WEST SUSSEX COUNTY COUNCIL CONSULTATION

TO:	Arun District Council FAO: Mr A Wood
FROM:	Highways, WSCC
DATE:	27/06/2018
LOCATION:	Jenin, Nyetimber Lane, Pagham, PO21 3JT
SUBJECT:	P/25/18/PL Demolition of existing garage, roof alterations to existing dwelling to provide first floor & 1 No. new dwelling in garden of existing dwelling. Amendment received.
DATE OF SITE VISIT:	
RECOMMENDATION:	☒ Advice ☐ Objection ☐ Modification ☐ No Objection ☐ More Information ☐ Refusal
S106 CONTRIBUTION TOTAL:	£N/A See below for breakdown.

Peter J. Gardner Architectural Design Consultant	
Job Title	Jenin, Nyetimber Lane Bognor Regis PO21 3JT
Drawing Title	Proposed New Dwelling Floor Plan
Client	R.B
Date	30/05/2018
Drawn	P.J.G
Scale	1:100 on A3
Drwg No.	NTL/P/01
A

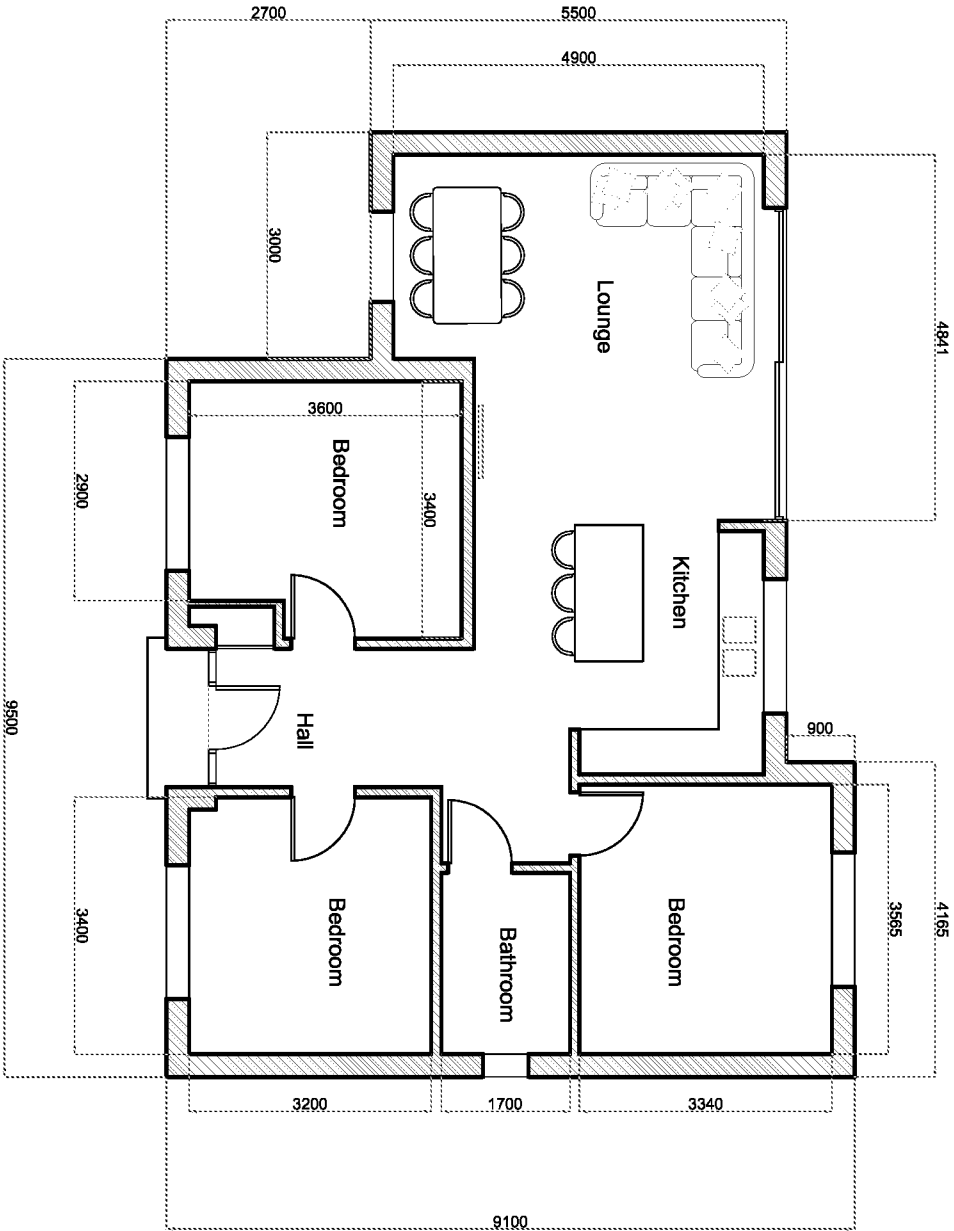
The additional information shows a reduction in size of the new dwelling. Applying the WSCC car parking calculator to the new dwelling would still require 2 car parking spaces. The LHA anticipate there would be sufficient space to park only one vehicle on the frontage. Additional parking could be accommodated by on-street parking as suggested in previous comments. However the Local Planning Authority (LPA) may wish to consider the impact of this application on on-street parking from an amenity point of view.

Job Title		Jenin, Nye/timber Lane Bognor Regis PO21 3JT			
Drawing Title	Block Plan Proposed				
Client	R B				
Date	12/05/2017				
Drawn	P.J.G				
Scale	1:500 on A3				
Dwg No.	NT/L/BP/02				B

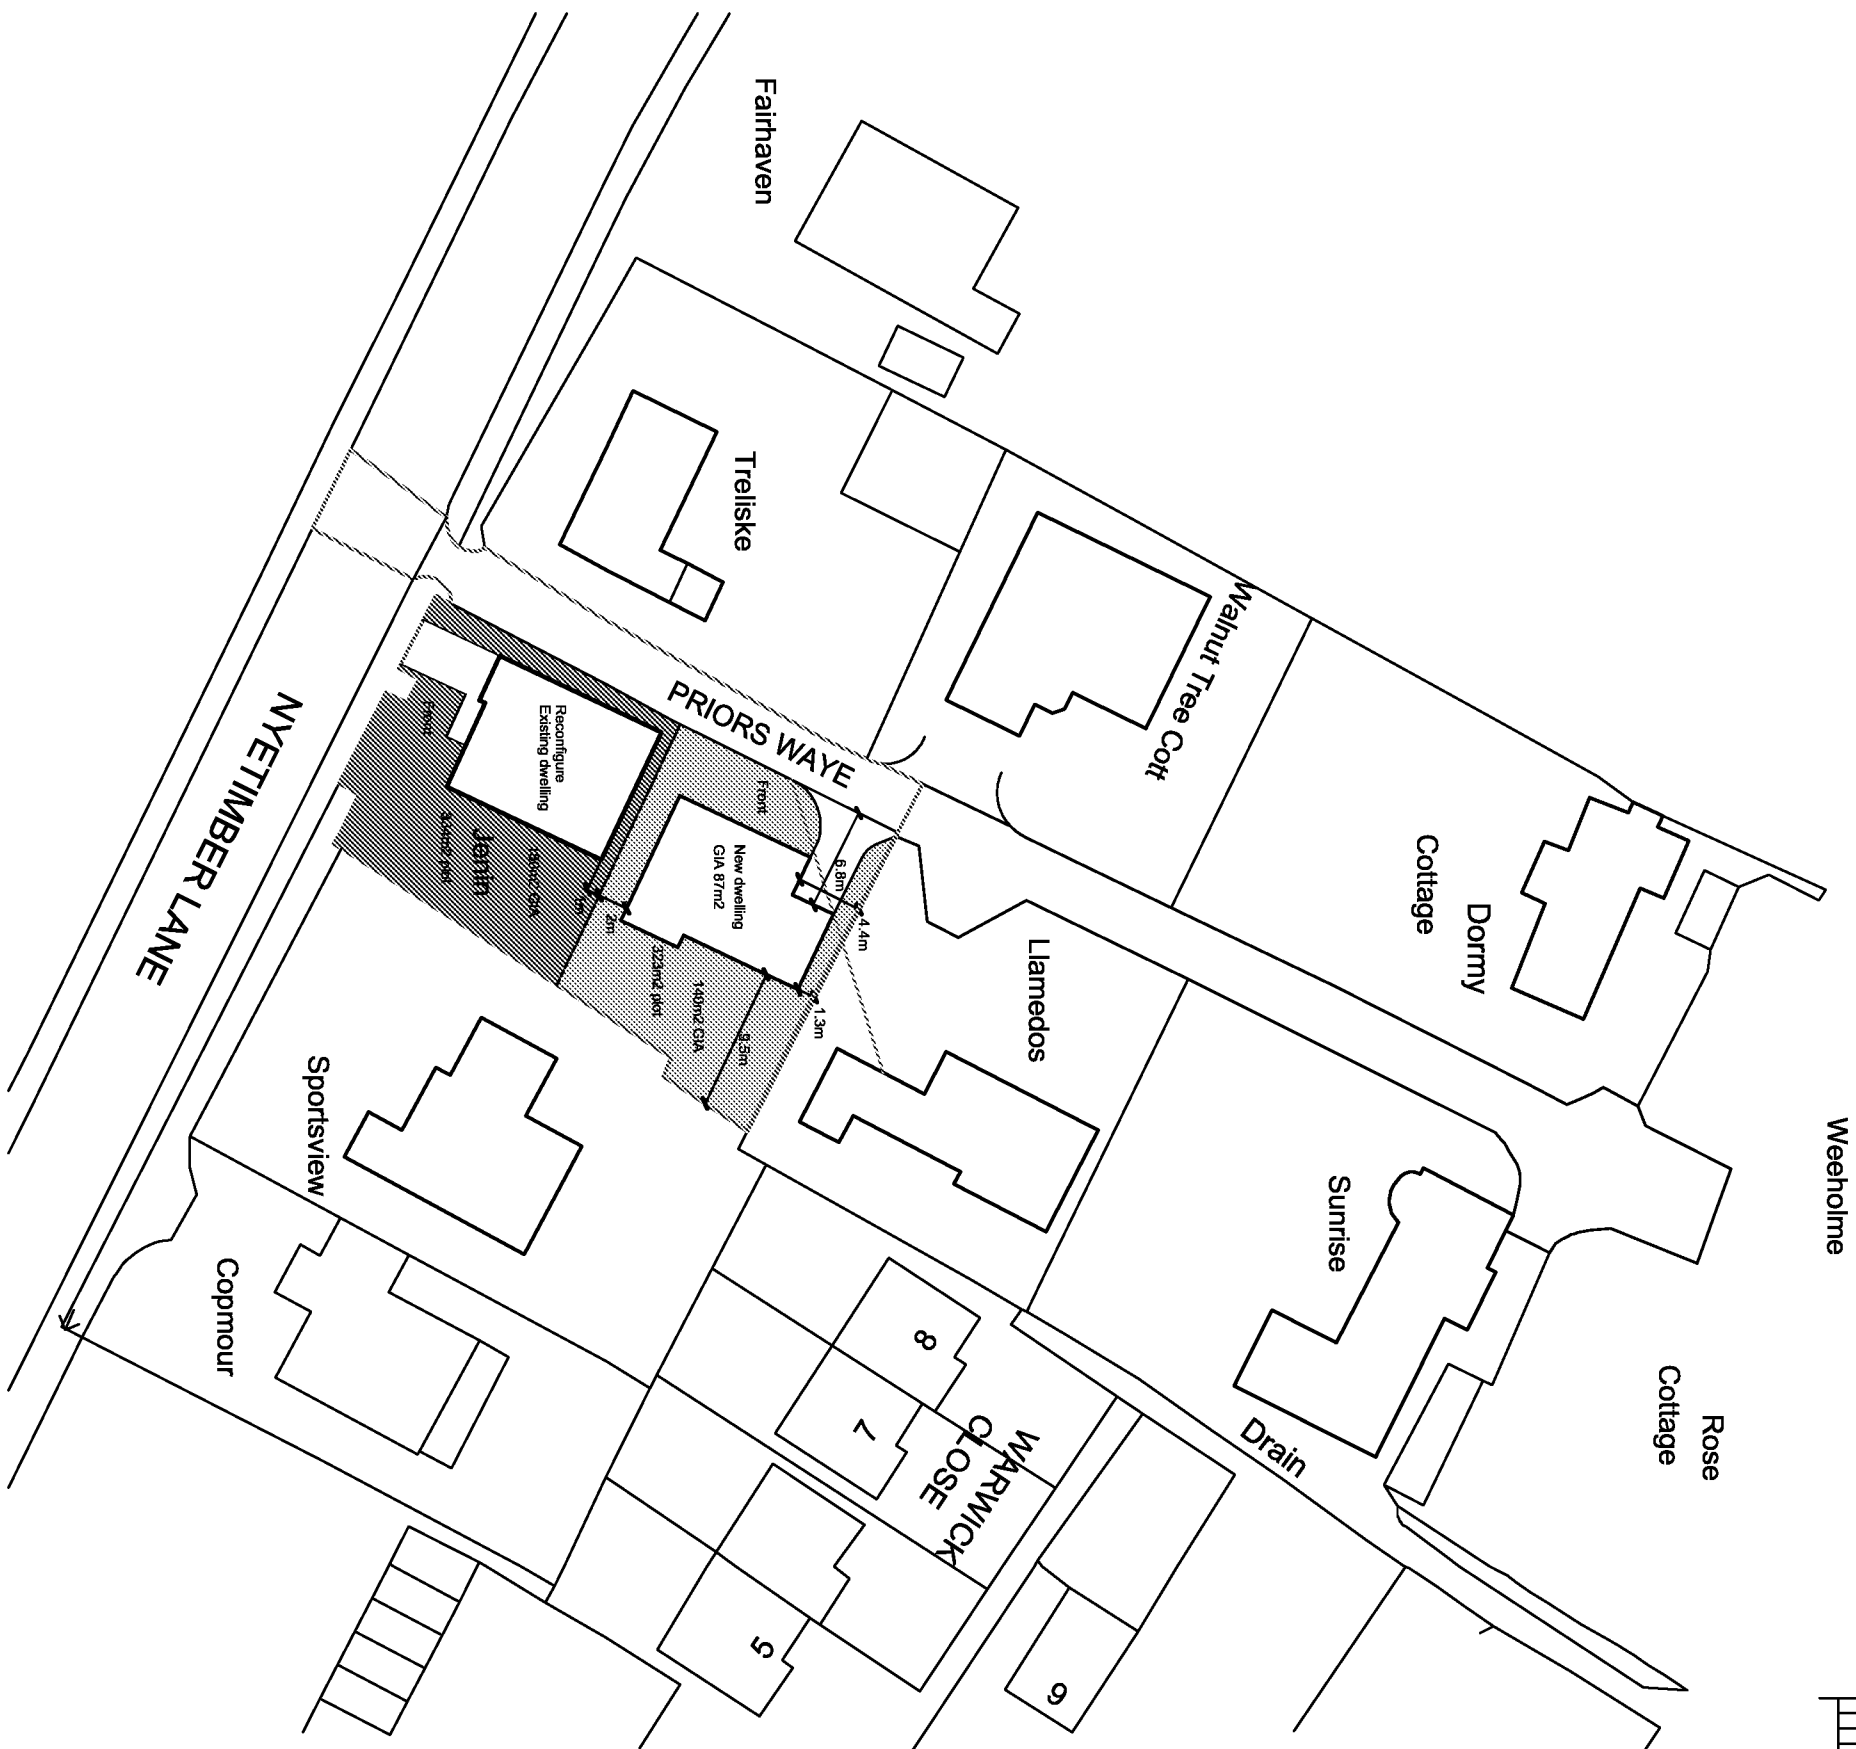
West Sussex County Council, in its role as the Local Highway Authority (LHA), was previously consulted on this application where the LHA asked for the applicant to clarify the total length of dropped kerb for the new access onto Nyetimber Lane.

The LHA does not consider that the proposal for a relocation of access for the existing dwelling and one new dwelling with associated access would have 'severe' impact on the operation of the Highway network, therefore is not contrary to the National Planning Policy Framework (paragraph 32), and there are no transport grounds to resist the proposal. All conditions and informative previously requested by the LHA are still relevant for this application.
